Re: Objection to MP08_0244 MOD 1 Modification Request for Mixed Used Development at 23-37 Lindfield Avenue and 11 Havilah Lane, Lindfield

As a resident of Lindfield, I/we wish to lodge an objection against the proposed Modification of the subject development based on the following grounds:

1 SHADOW DIAGRAM - 21stDEC_9AM
5003 SCALE1 : 650

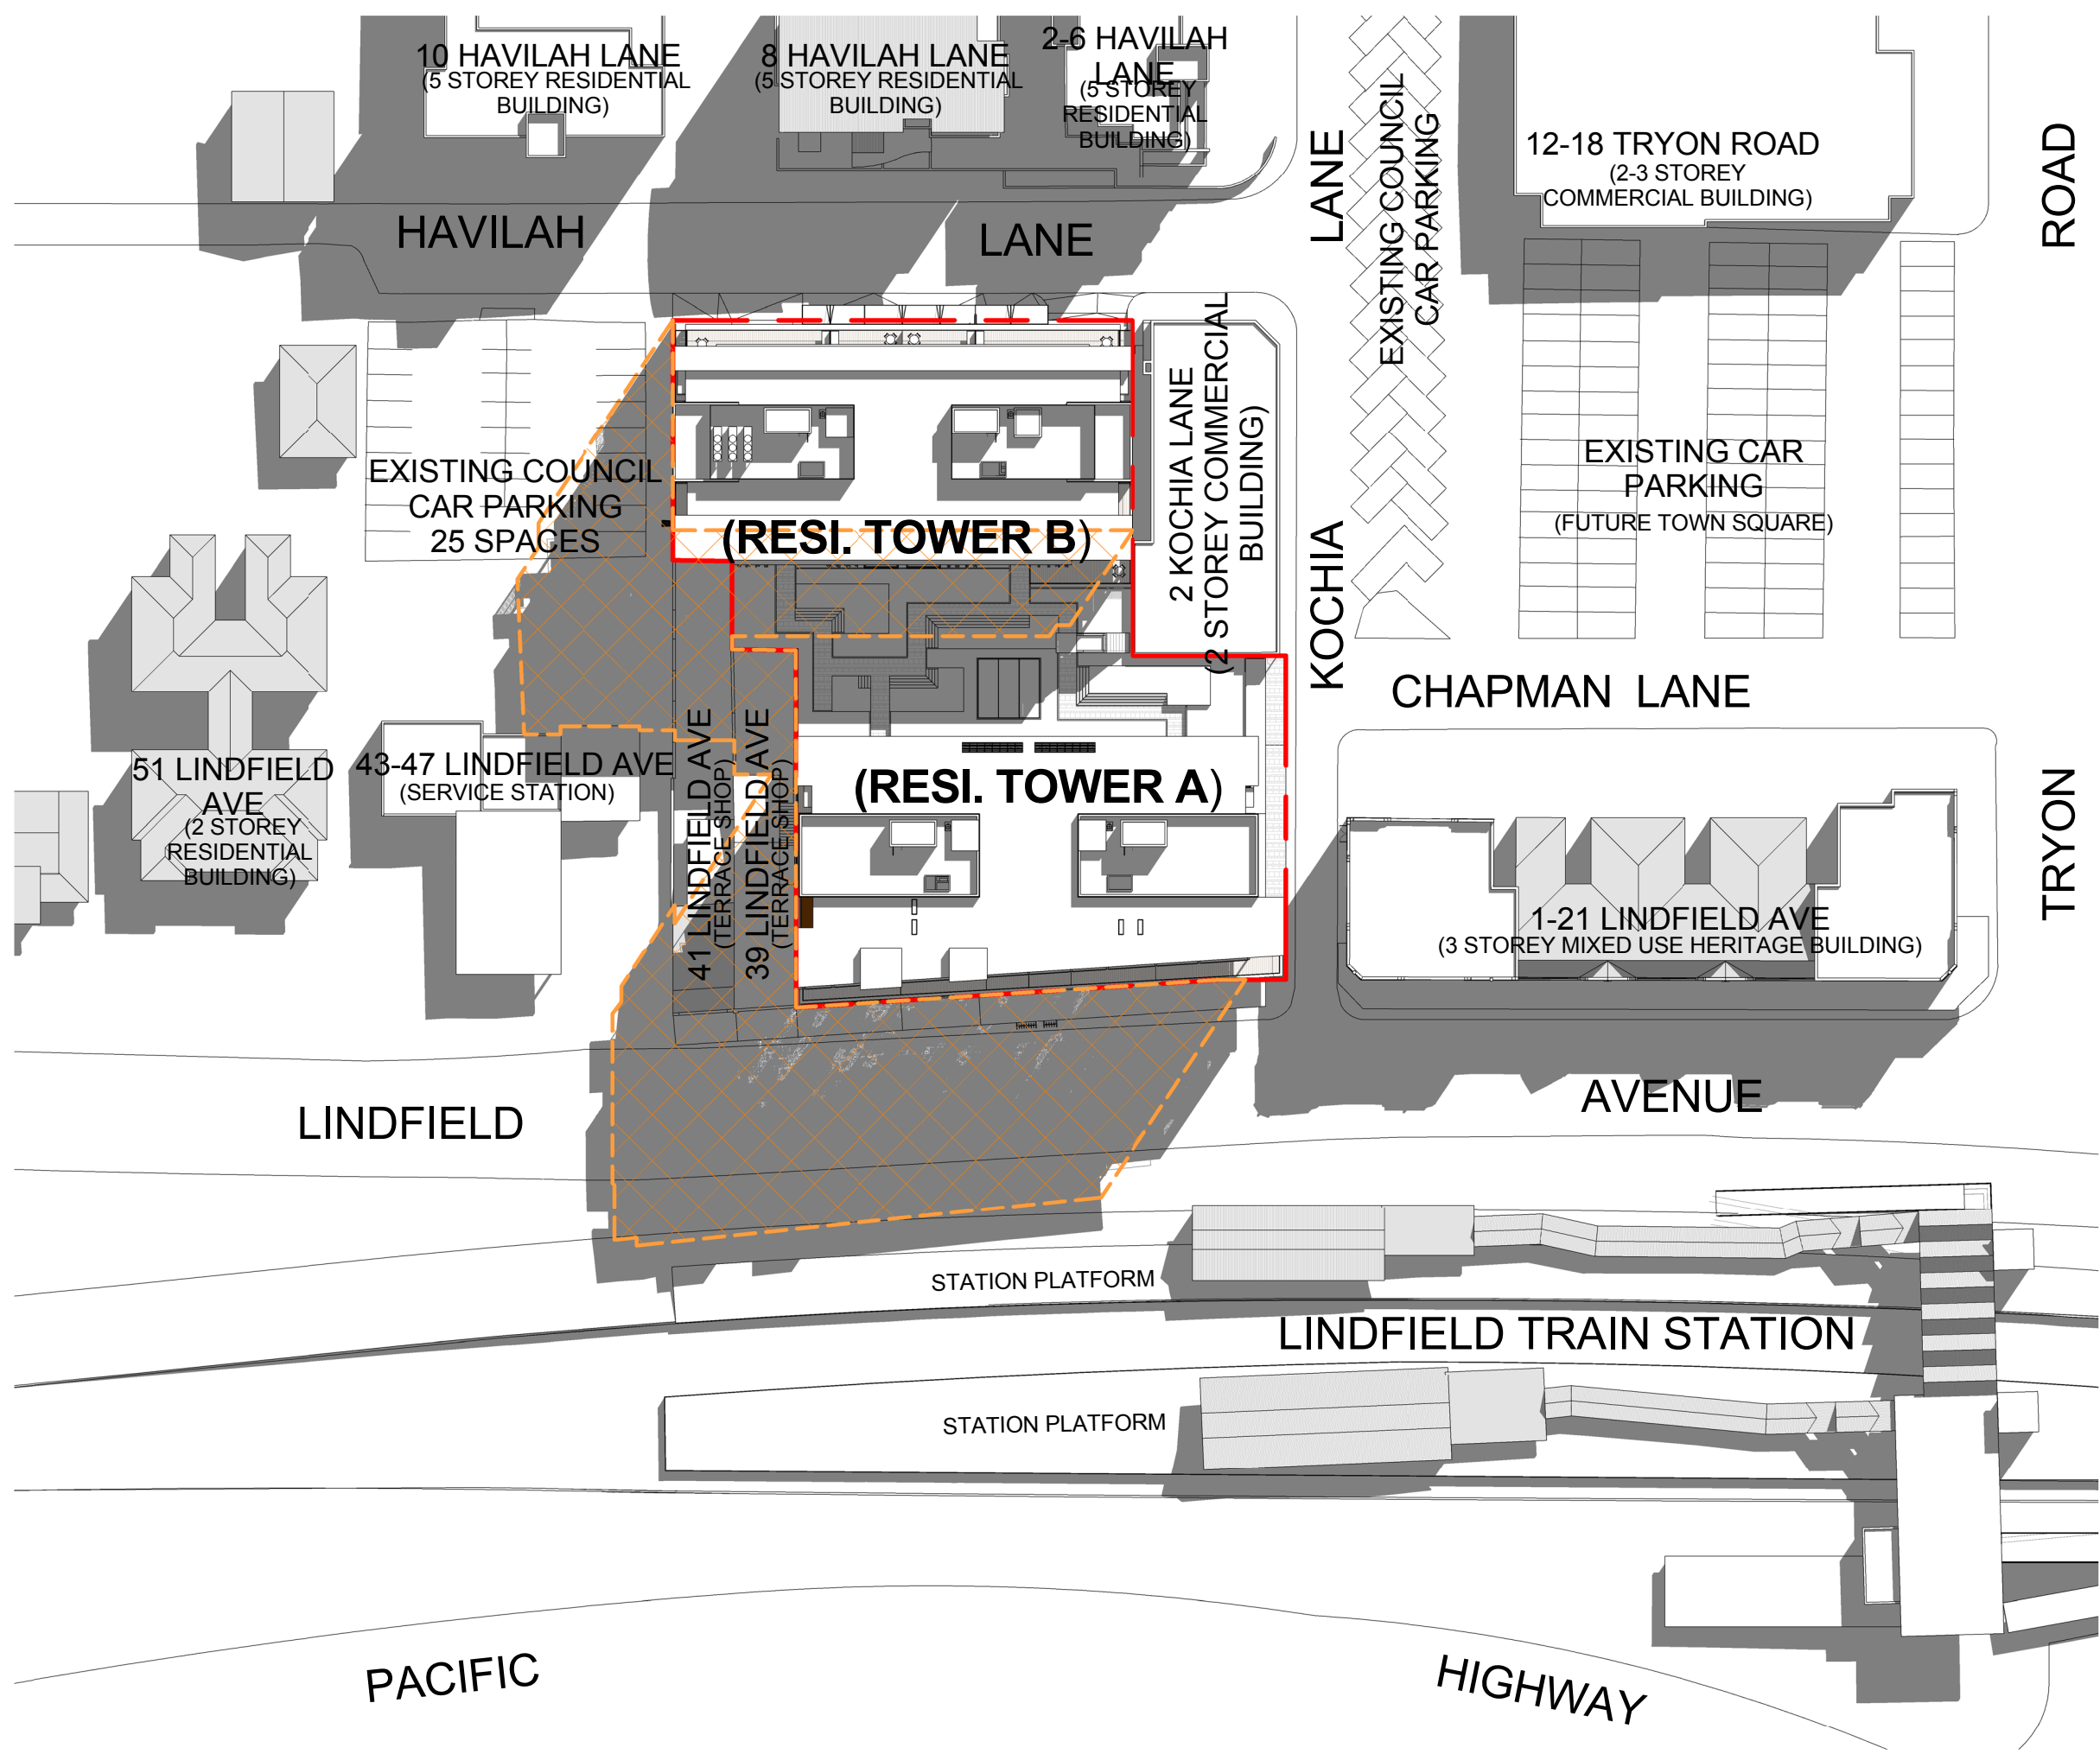
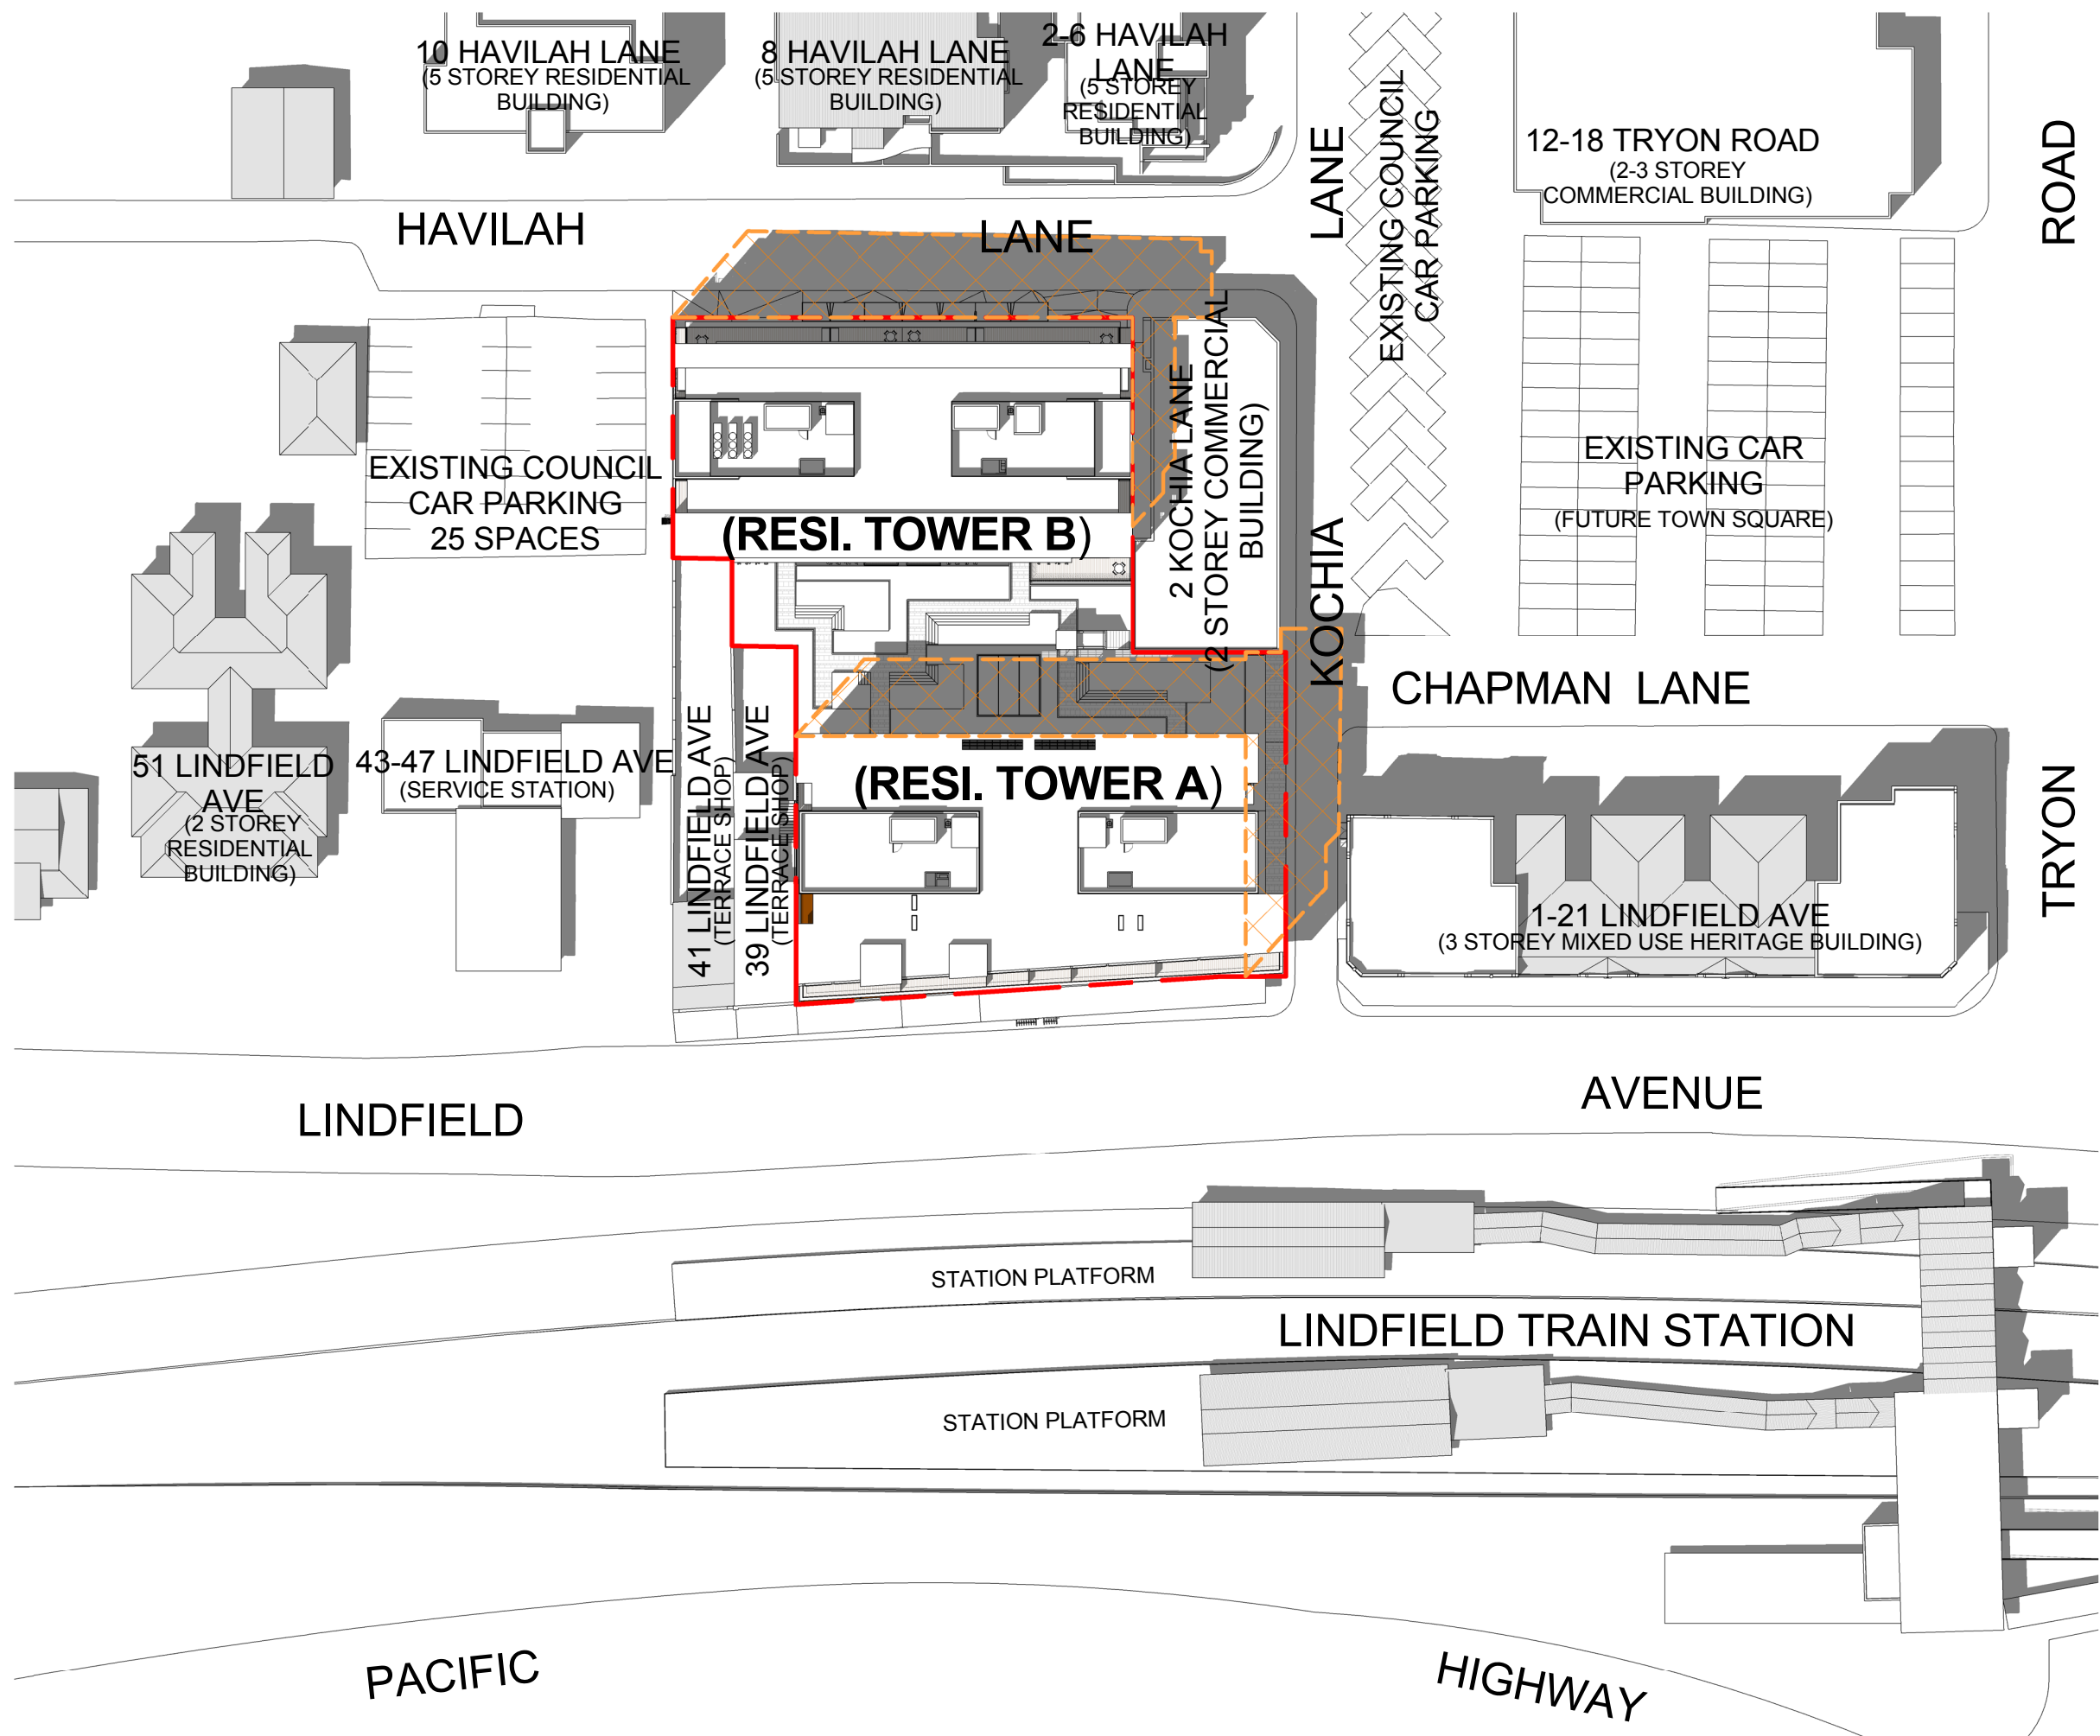
- The additional storeys create new adverse shadowing: a) for residents in the Havilah Lane apartments particularly after 3pm b) for the popular outdoor café and central Lindfield hub area at 12 Tryon Road in afternoons, particularly in winter and c) for all commuters on the city bound Lindfield rail platform, instead of 50% of the year as approved, it will now be in shadow in the mornings 75% of the year
